**Orange Private Hospital Modification 4 (MP08_0233 Mod 4)
Request for Additional Information**

PROJECT
BLOOMFIELD PRIVATE HOSPITAL
ADDRESS
FOREST ROAD ORANGE
DRAWING
LANDSCAPE MATERIALS PLAN

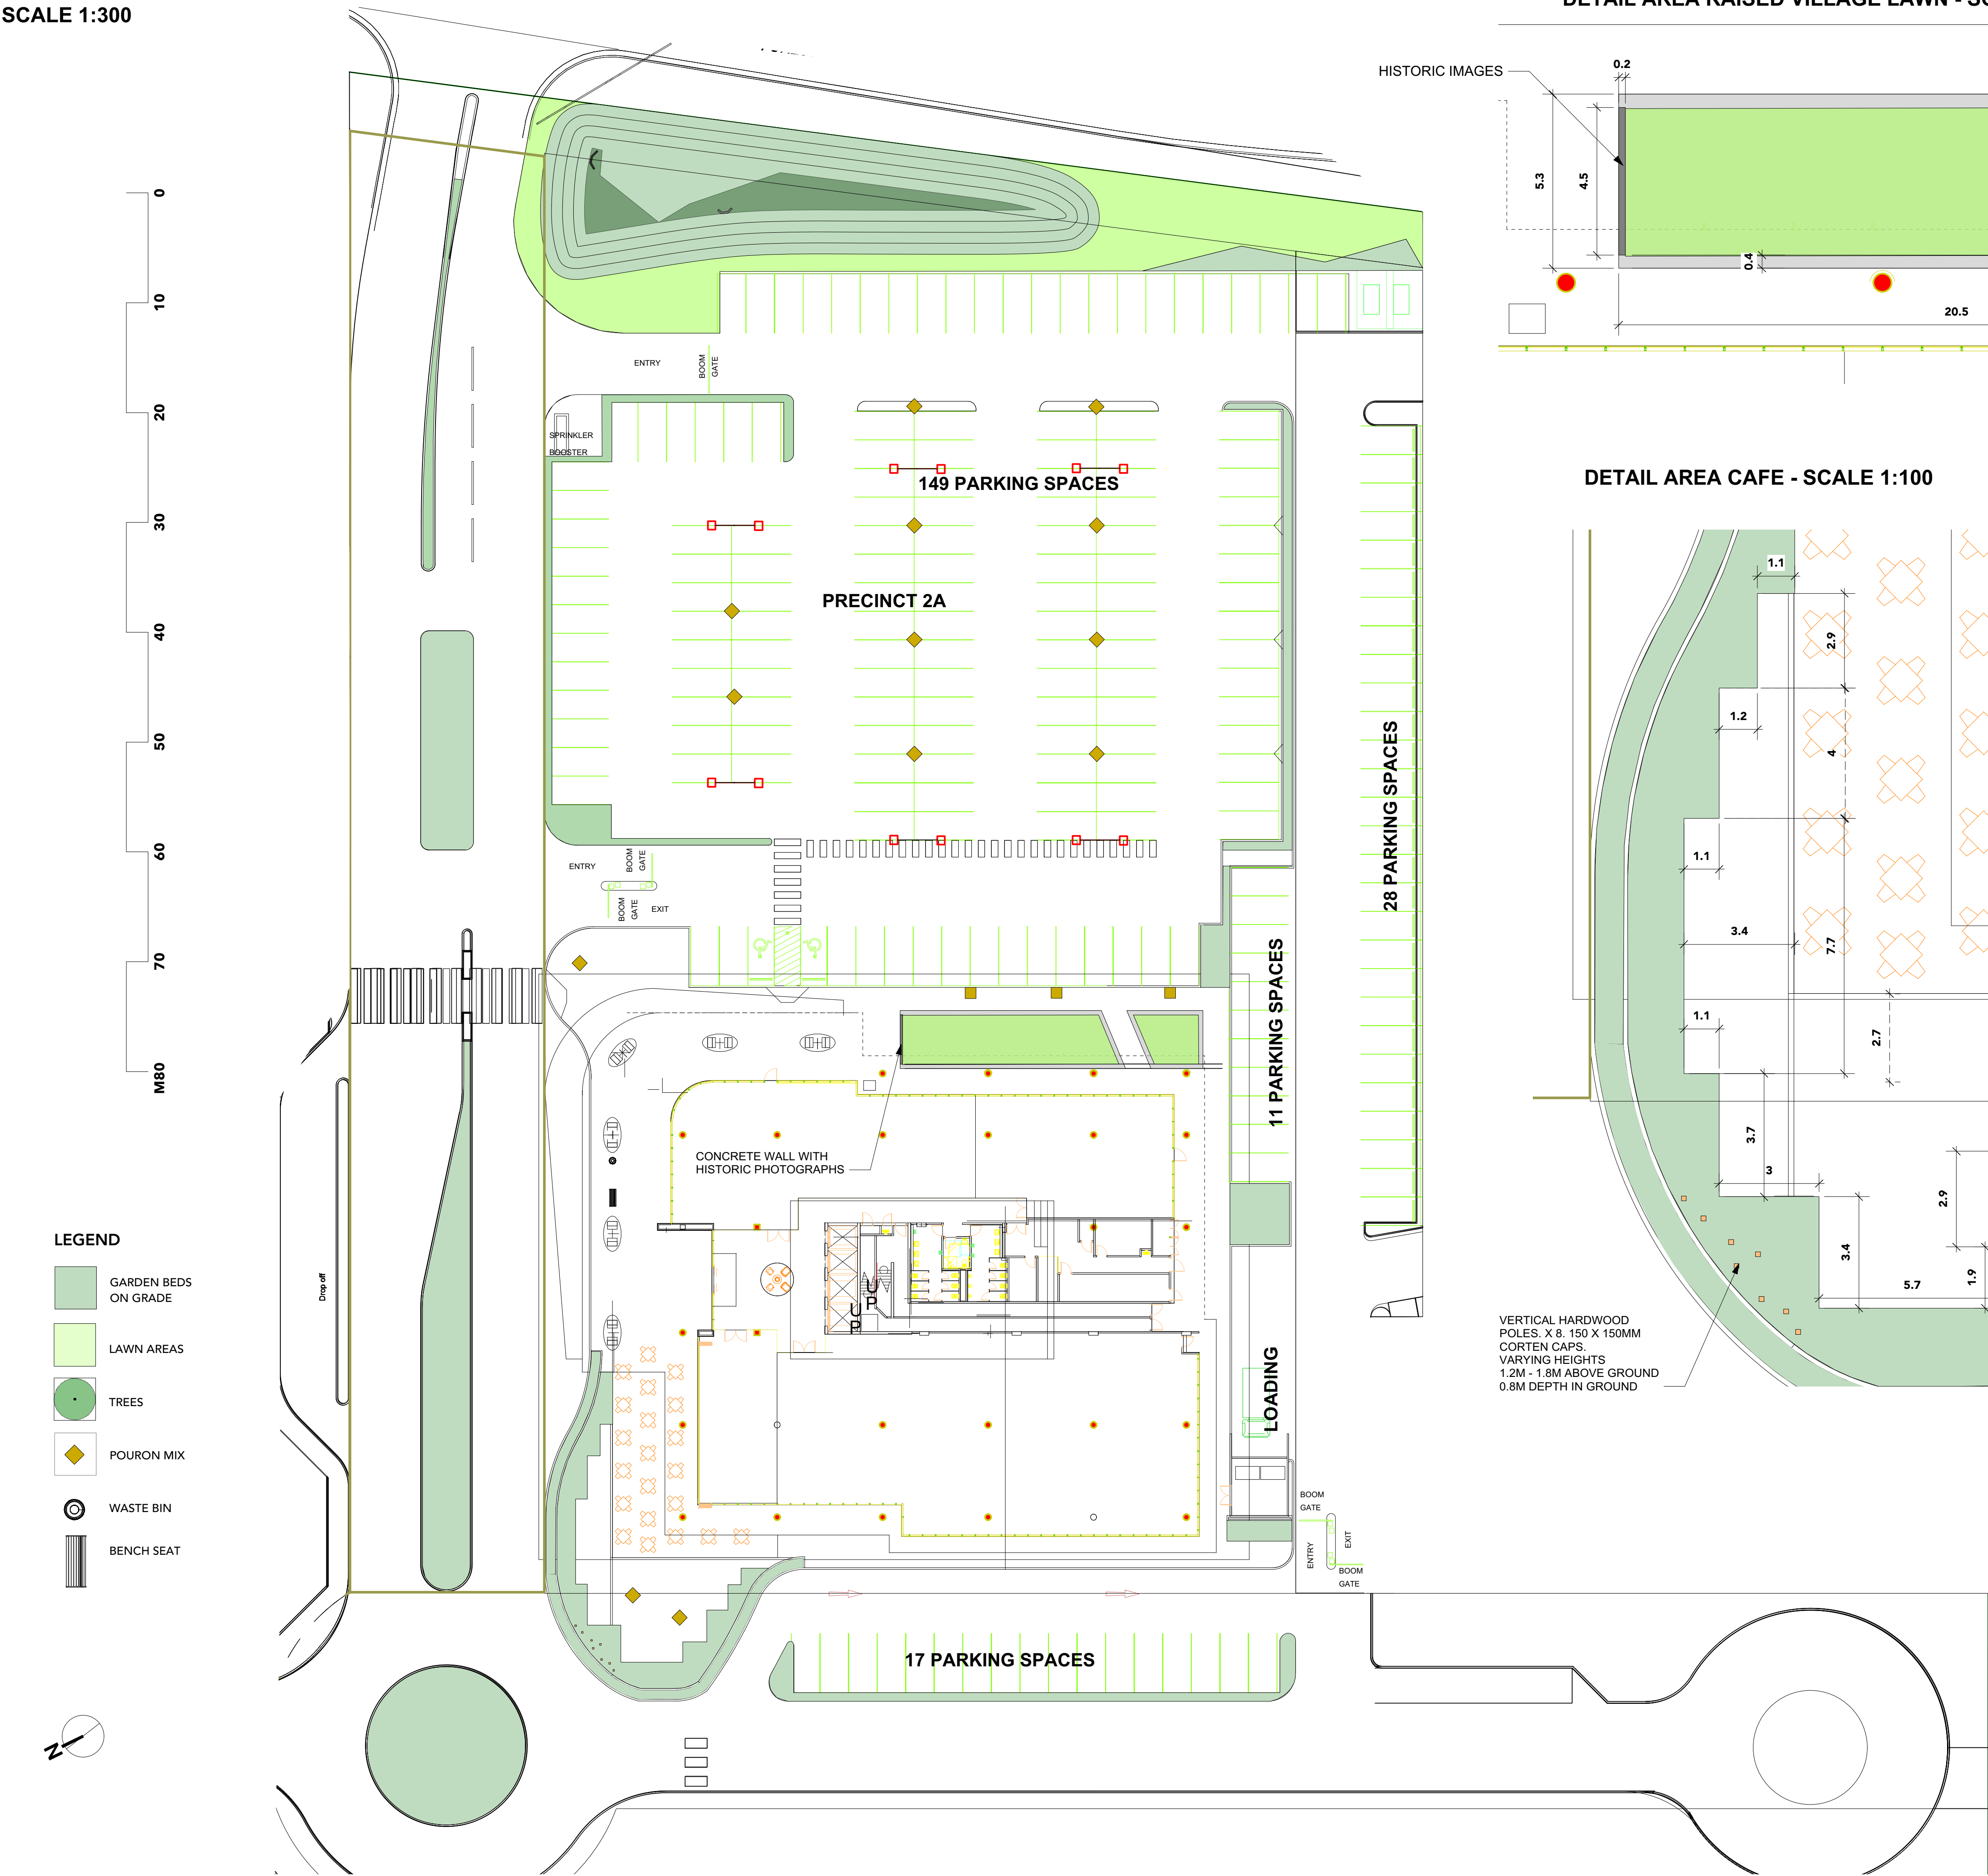
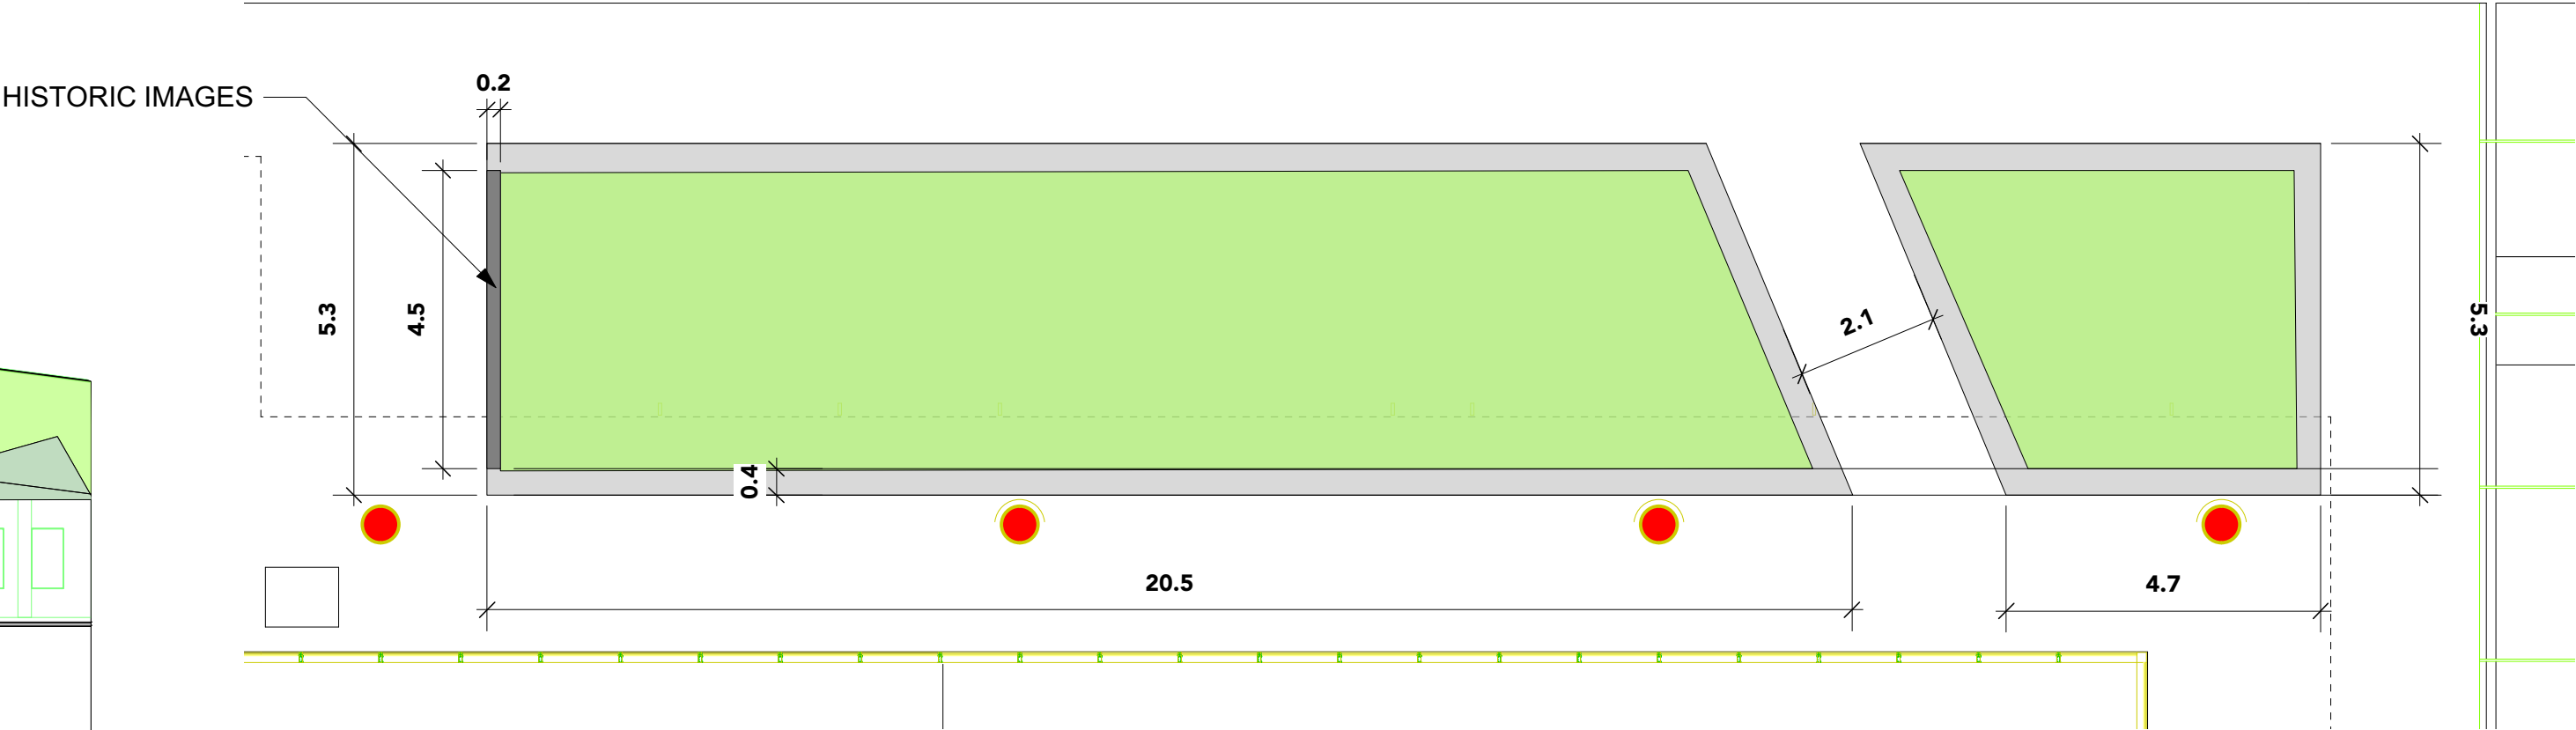
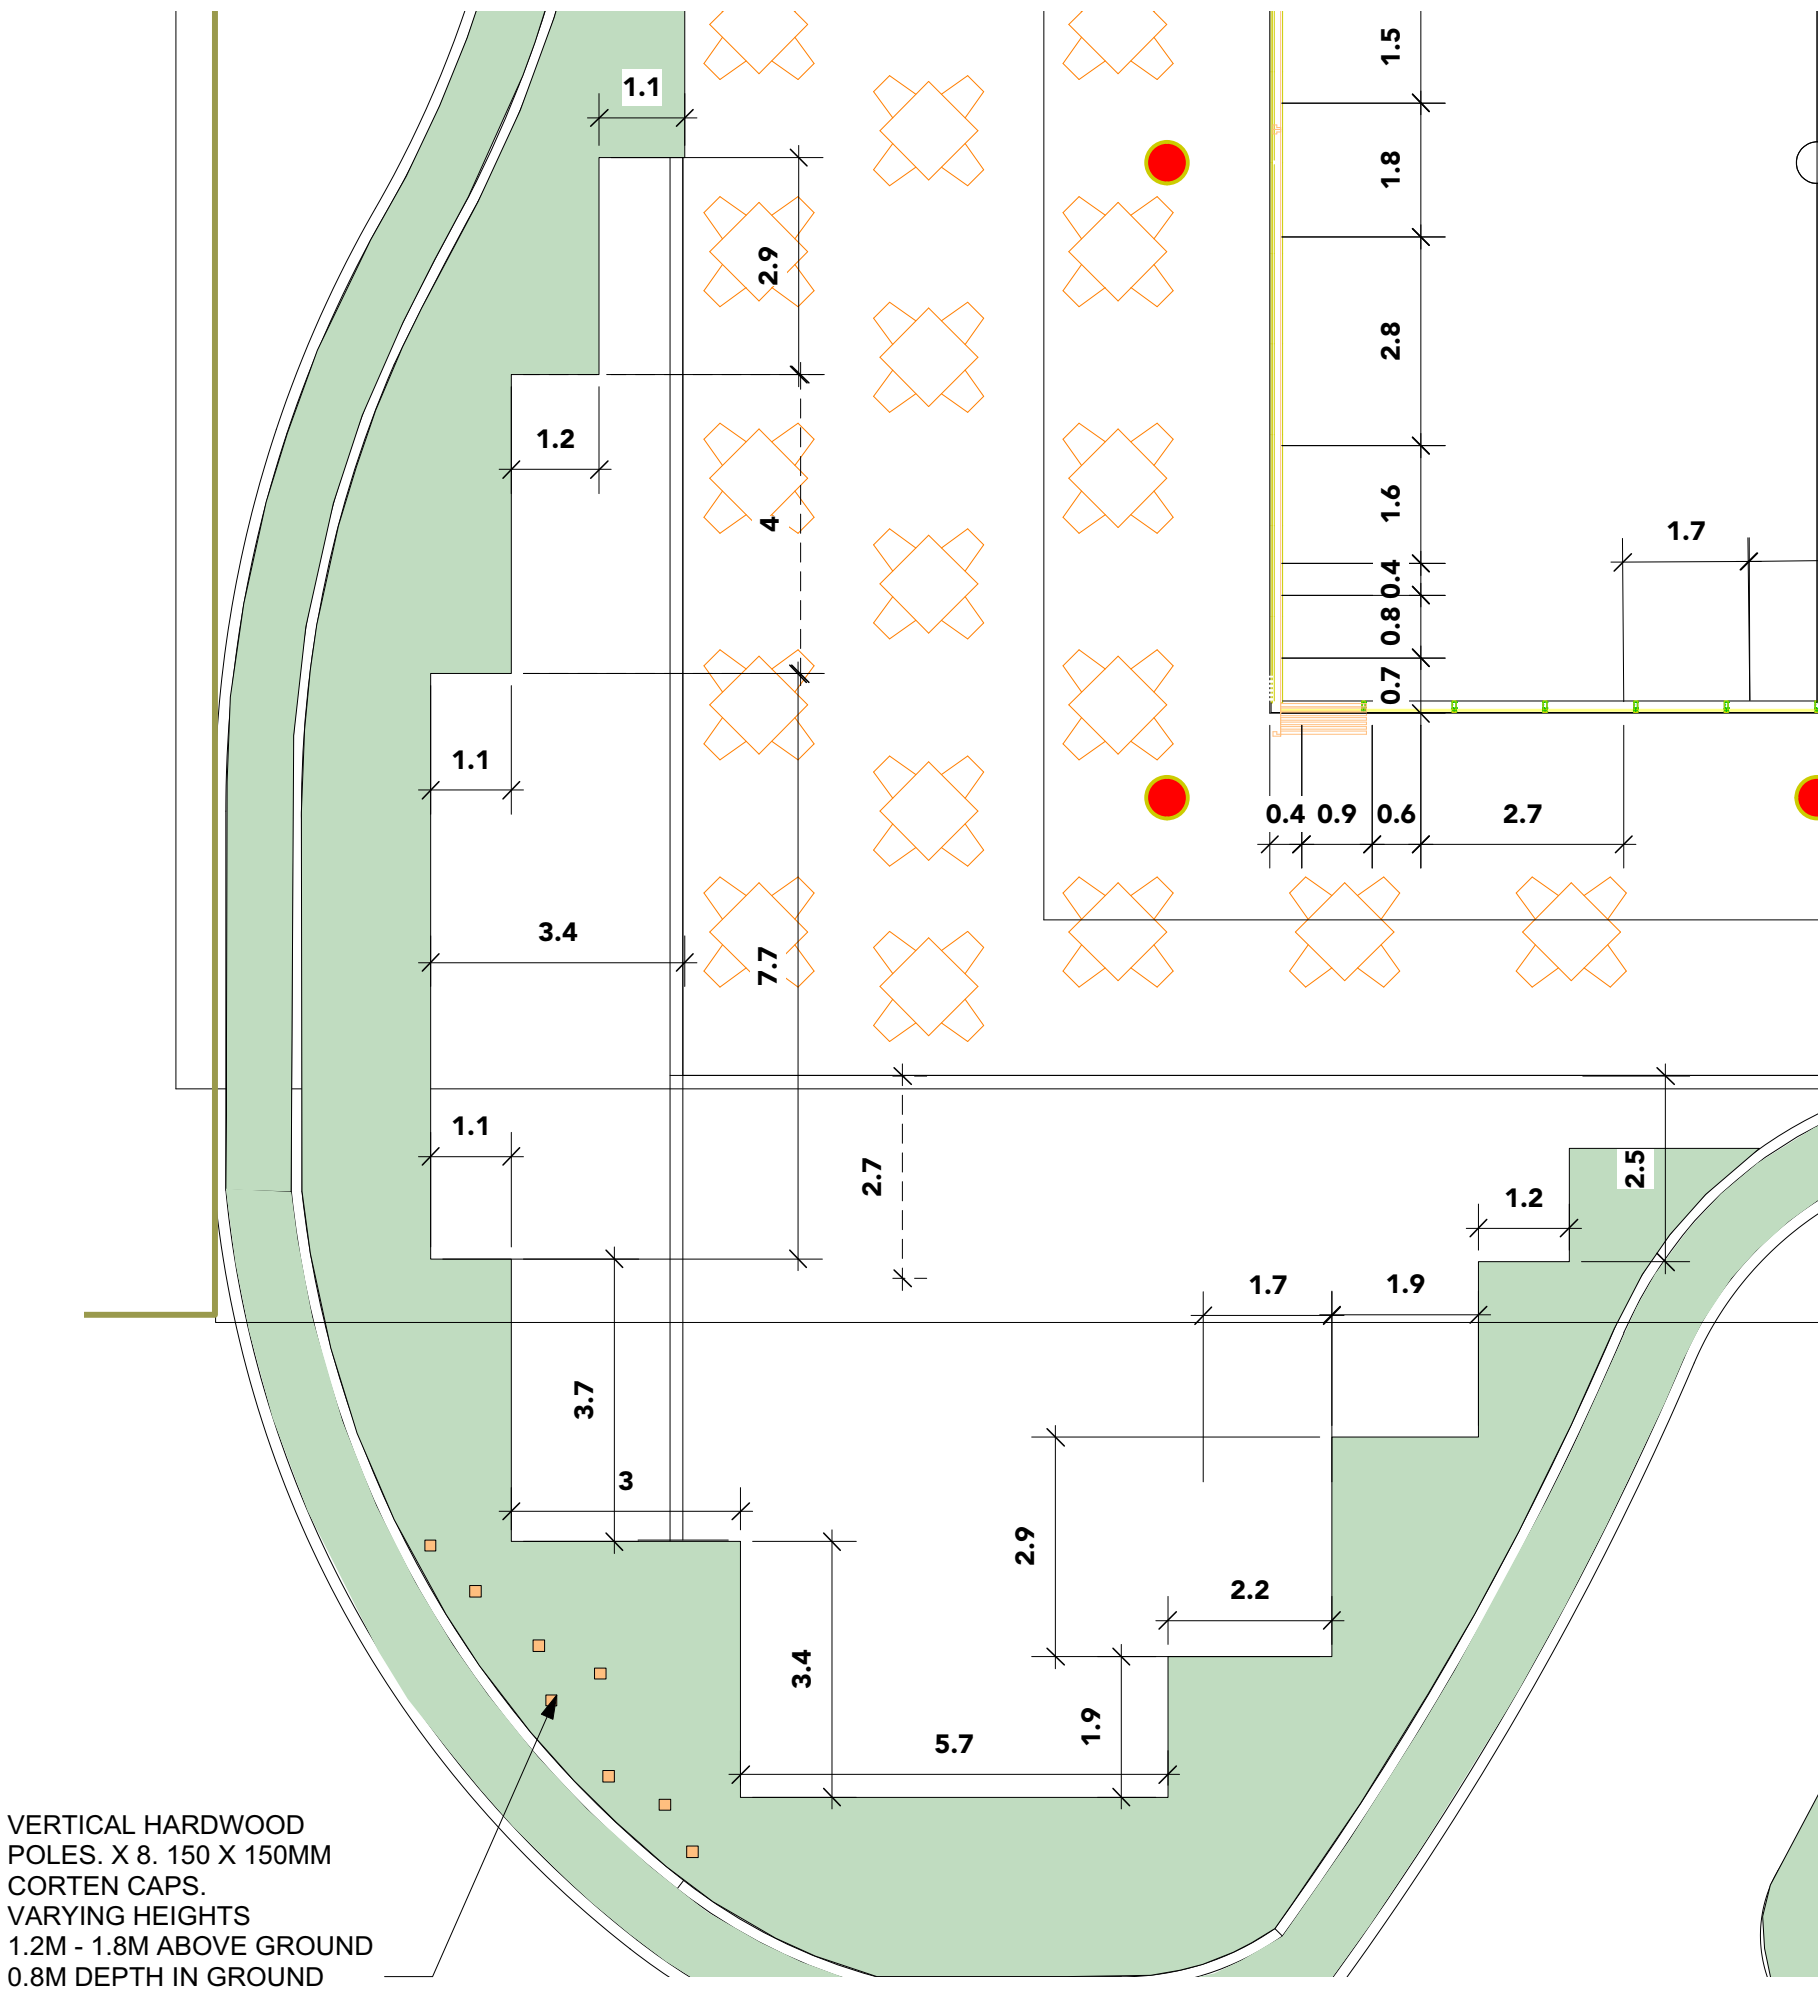
- reasoning for the loss of trees onsite as a result of the site reconfigurations. Landscape plans are to be submitted demonstrating changes to tree planting from previously approved plans.
- justification for the roof top enclosed space and why this should not be considered gross floor area (GFA). If the enclosed space is considered GFA, appropriate action should be undertaken regarding the concept plan GFA total. In addition, further details of the rooftop garden proposed should be provided.
- as the submitted location plan Drawing Number SK02, Rev H dated February 2017 appears to have a drafting error which shows an area of landscaping covering the southeast corner of the reconfigured Medi-Motel, an updated plan is to be submitted.
